Application No: F/21/24/PL

Site Address: Land rear of Waterbury House Ford Road Ford BN18 0BH

Description of works: Erection of 4 No supported living units (C3(b)), office block, car parking and associated works. This application is a Departure from the Development Plan, affects the setting of a listed building and is in CIL Zone 3 and is CIL Liable as new dwellings.

Thank you for your internet representation made on 22nd July 2025 which has been recorded as an objection with the comments as follows:

PROPOSED STREET ELEVATION

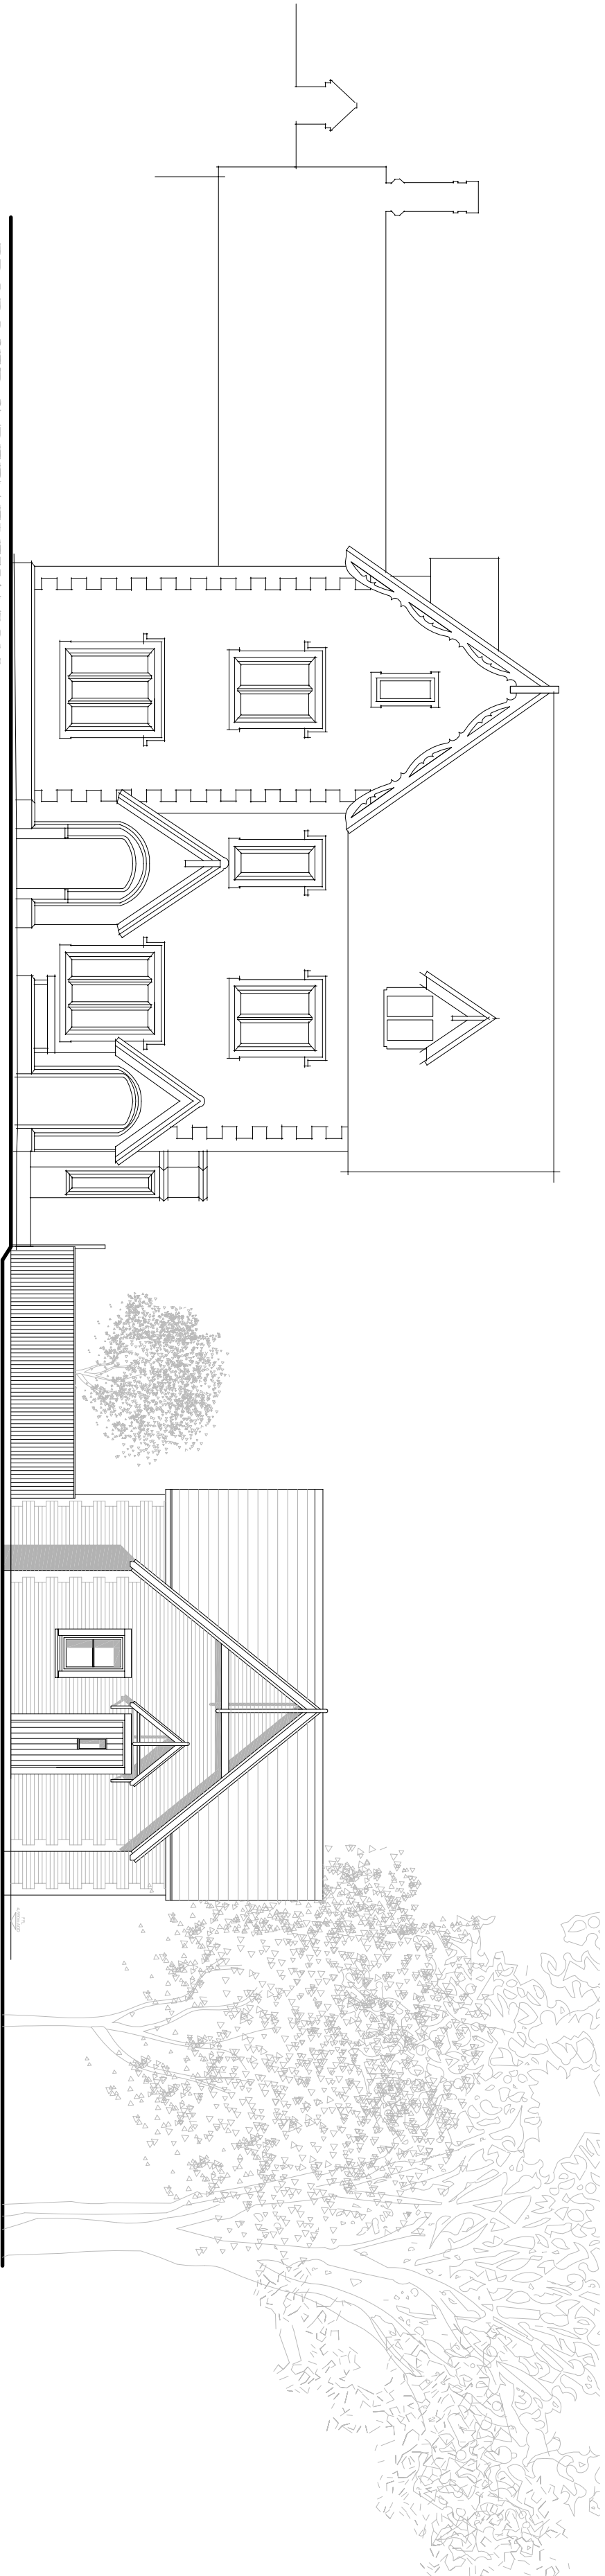
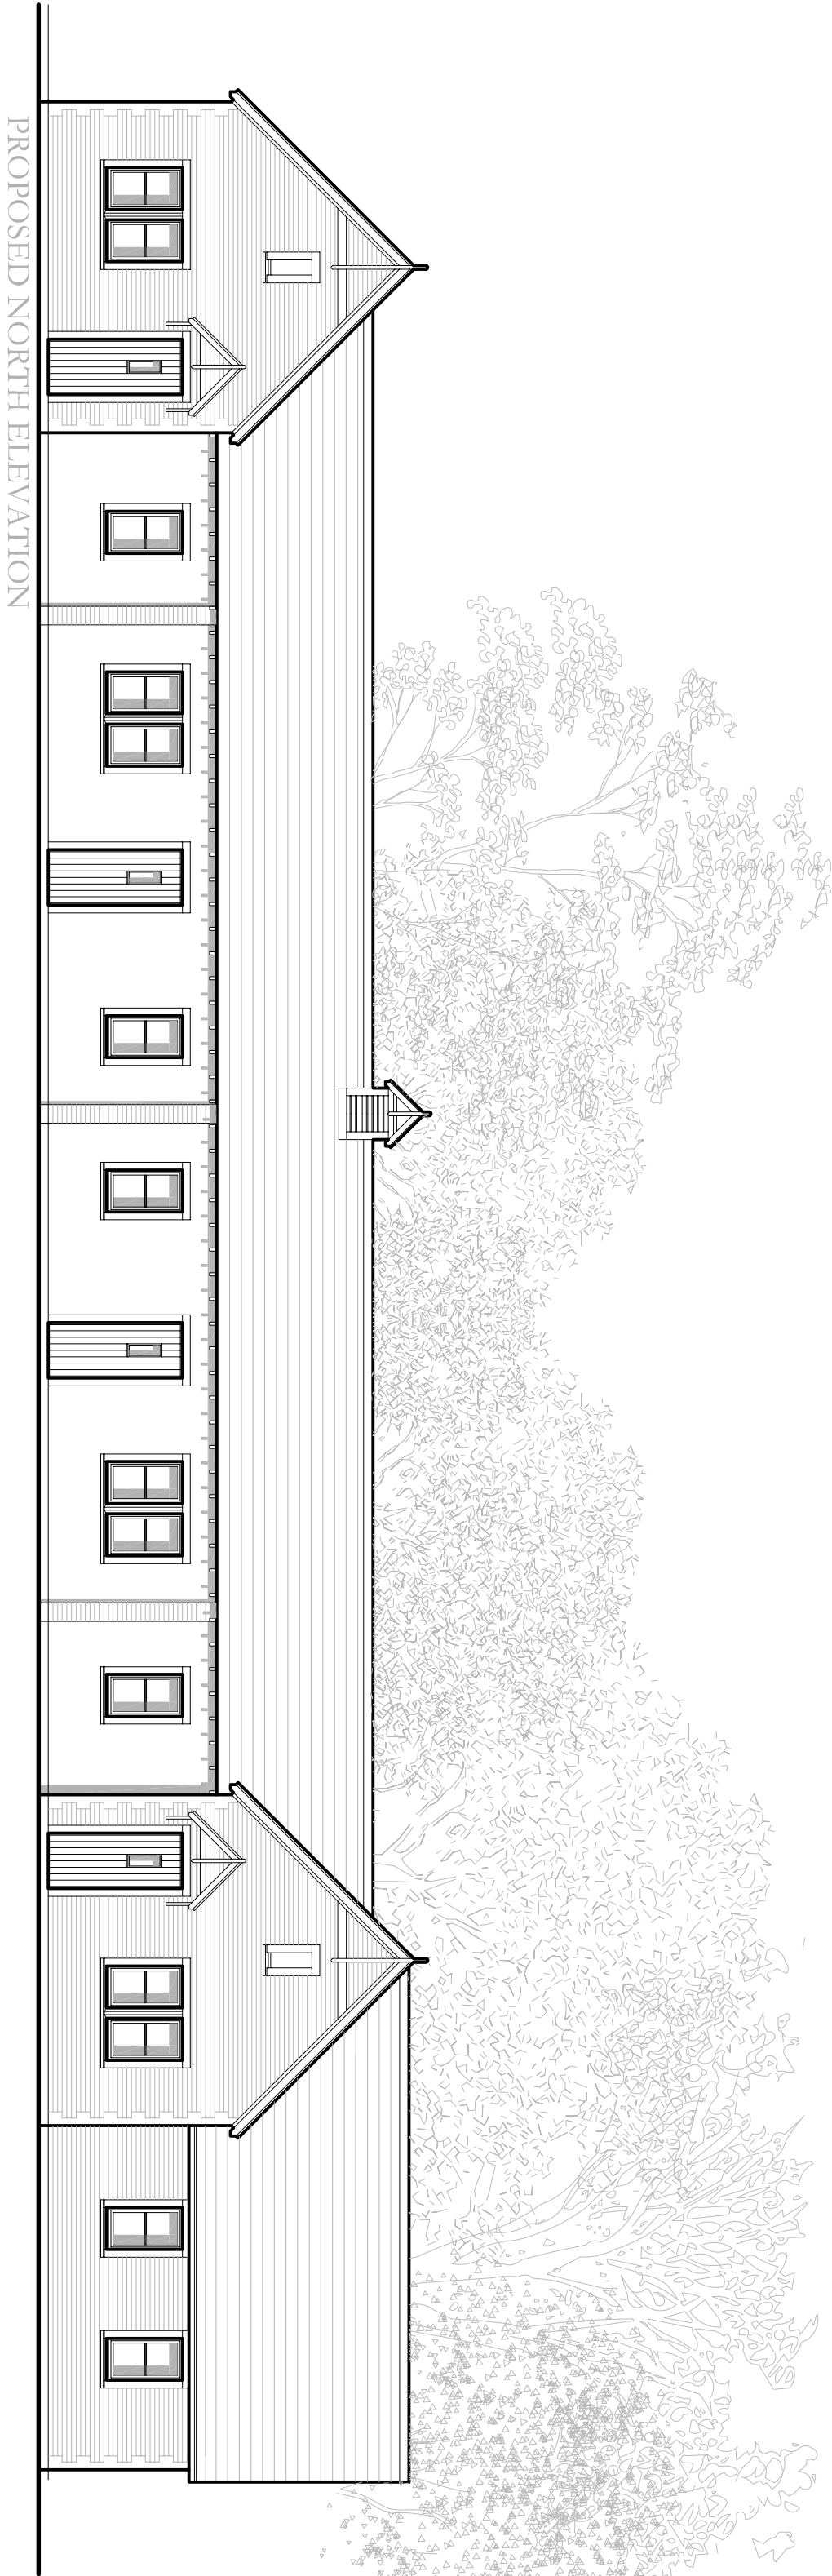
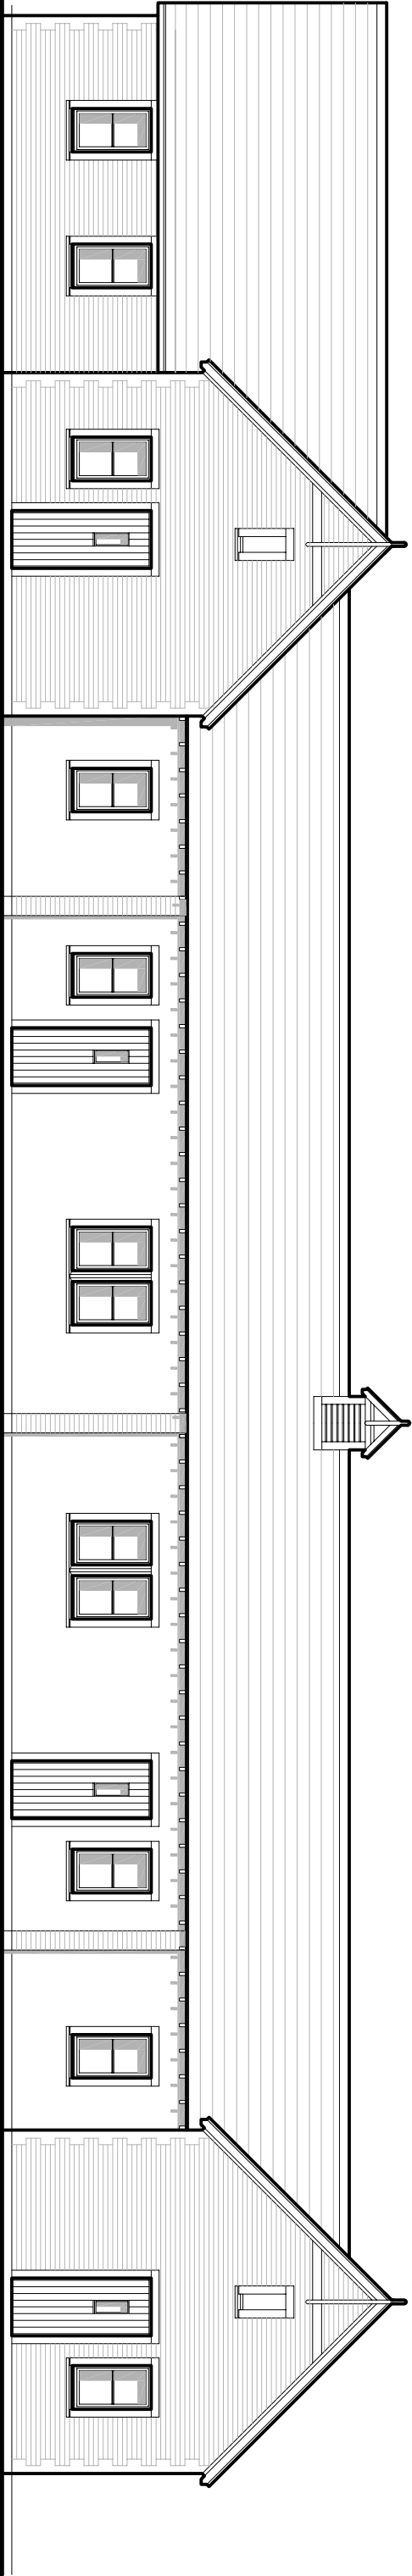
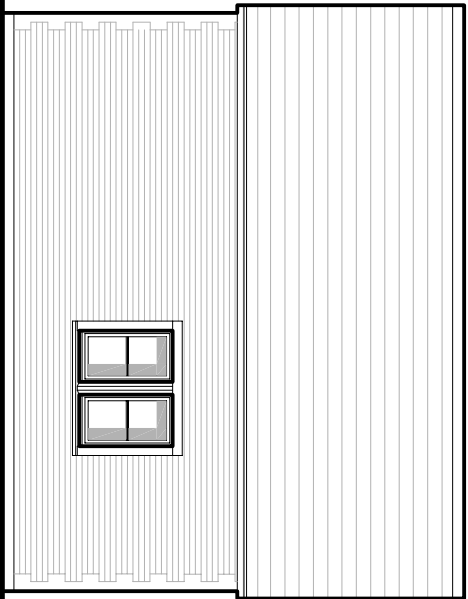
Would like to know completion height of roof ridge top above wooden boundary fence in other words how much am I going to see from my bedroom window of said building ???

Plans do not show this..will there be any planting of trees to block view and keep my privacy???
??
